# MEMORANDUM

## Waste Management Comments

APPENDIX: A.1 GROUND FLOOR PLAN SNAPSHOT – BIN STORAGE AREAS

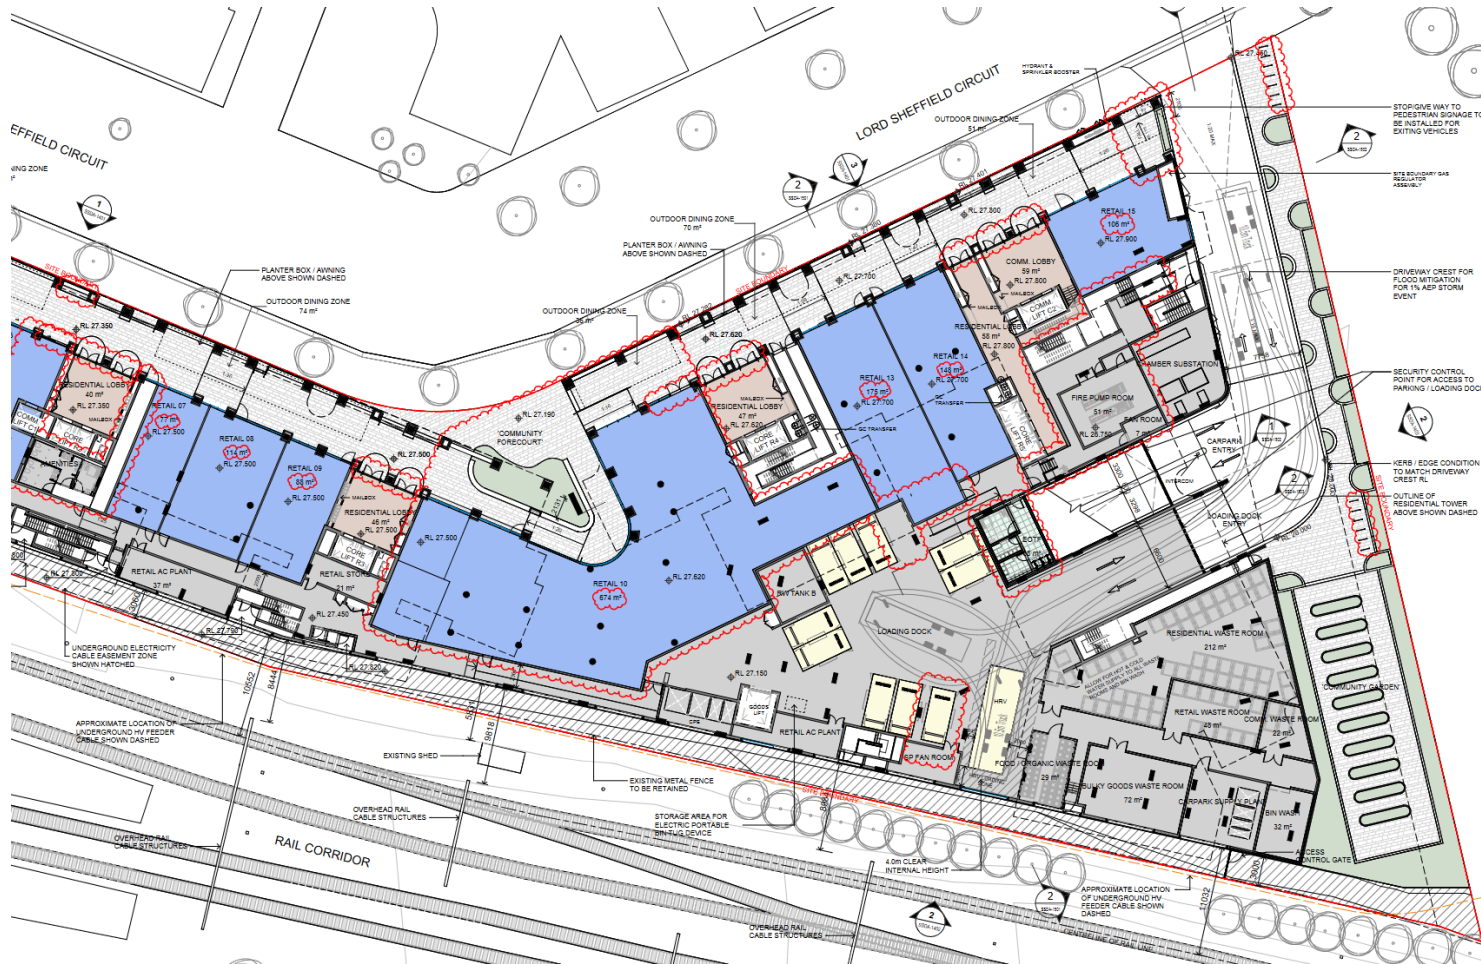
Additional service vehicle spaces have been added within the ground level loading dock. These spaces inhibit the previously available routes from the goods lift to the collection rooms. The route available involves a number of turns that will require staff to redirect heavy bins repeatedly between the goods lift and the collection rooms.

The locations of pillars adjacent to the turn paths required for the waste collection vehicle within the Loading Bay reduce the available space for manoeuvring and margin for error. This increases the likelihood of impact between a collection vehicle and a pillar resulting in implications for the structural integrity of these features.

Noting there are several access points to the loading dock directly from commercial premises, the State should consider how access to the loading dock will be managed to ensure that there is no conflict between staff from commercial premises and service vehicles / collection vehicles operating within the loading dock.
